**Cc:** [Geoff Scherer](#); [Aaron Lowe](#); [Darren Higashiyama](#)  
**Subject:** RE: ACU-26-00001 and SE-26-00005 Mountain River Trails - Notice of Application

CDS is requesting comments on the following CUP/SEPA application: **ACU-26-00001 and SE-26-00005 MRT**. Links to the file materials can be found below. Kittitas County anticipates issuing a DNS for this project application and is using the optional SEPA process. This may be the only opportunity to comment on the ecological impacts of this project.

MOUNTAIN RIVER TRAILS

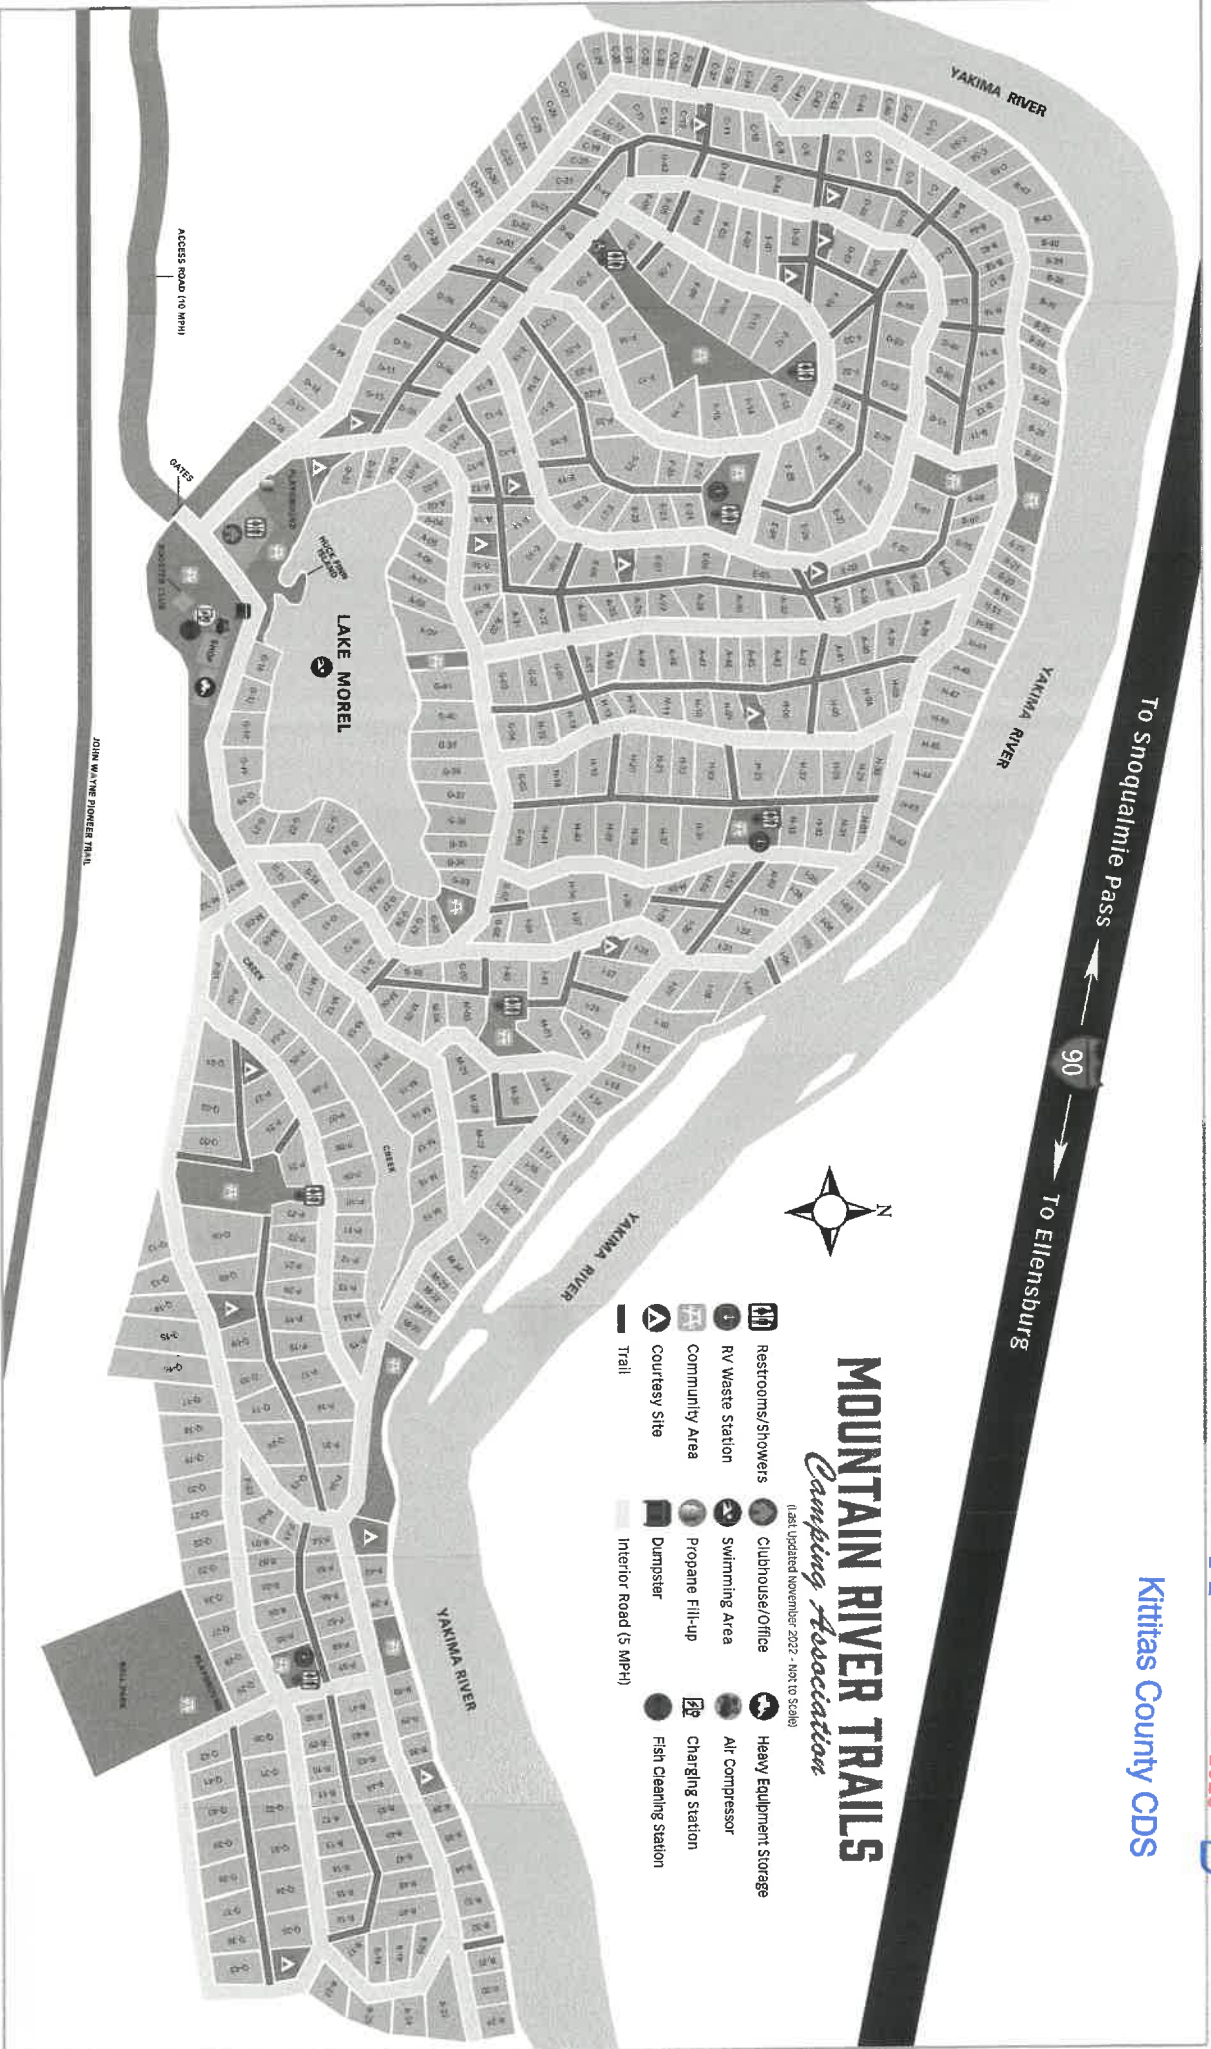
Jamey – this particular campground raises numerous addressing related issue. We view this as an opportunity to reset and make sure that the addressing architecture is correct, the sites addresses are logical and follow a pattern, and that all sites are clearly marked from both directions of travel. This is a public safety issue that has existed for years. As it stands now, the addresses do not validate as 1000 Mountain River Trails Rd #10A, #6F, 14B, Clubhouse, etc.
